Job Number: 6150

***New Sydney Fish Markets***

***Structural Engineering commentary regarding the alterations required in line with SSDA8925 Modification 3 Basement Modifications***

AR-S2-B10 LB1-01 J

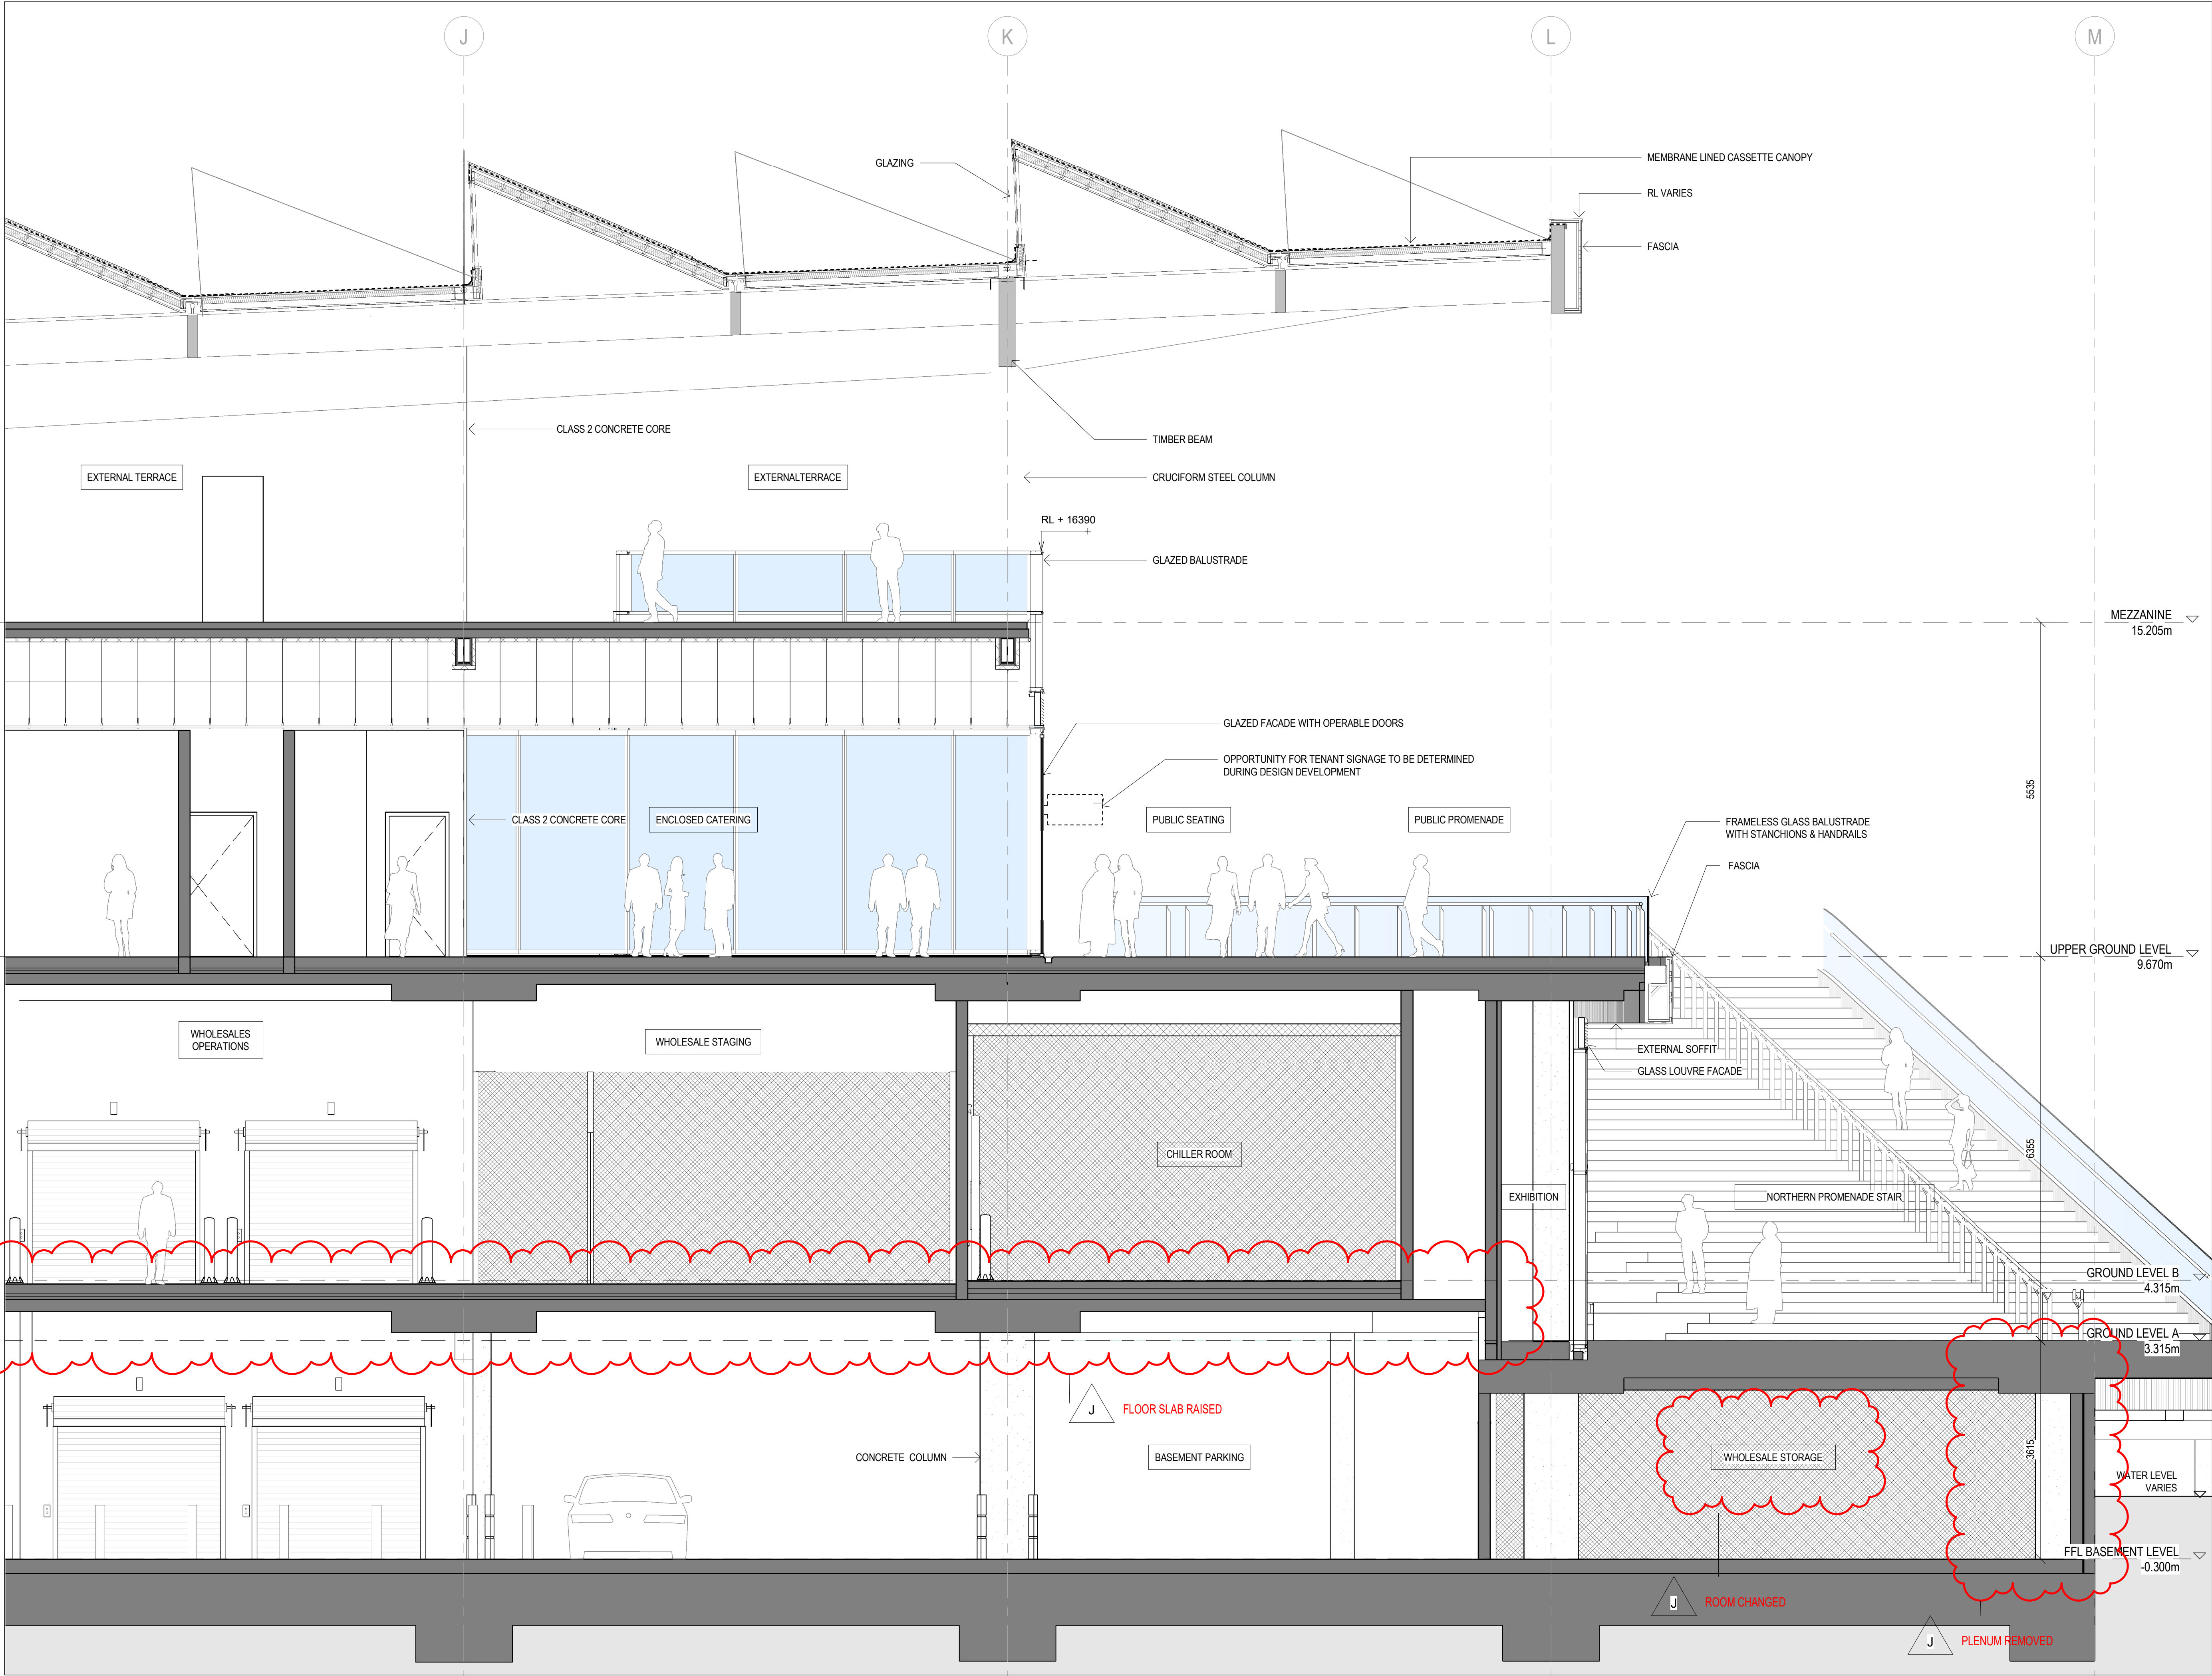
The main structural changes required by Modification 3 include changes to the basement external wall position with a subsequent relocation of heavy plantroom and tank loads within the basement footprint.

In addition to aid buildability the building's raker piles have been relocated from the base of the four main building cores to now being installed on grid A using land based installation methods in lieu of the marine based methods alluded to in the Design Report. The proposed location of the land based rakers and the existing sea wall will now clash, in part, with the new basement extent and modifications to these proposed structures will be required.

We have assessed the impact of the changes required by Modification 3 to the structural design of the new Sydney Fish Markets against the previously submitted Structural, Civil and Maritime Design Report (MOTT-RPT-385951) revision J authored by Mott MacDonald Australia Pty Ltd (Design Report) and confirm that the basement redesign is in line with the principles setout in this Design Report.
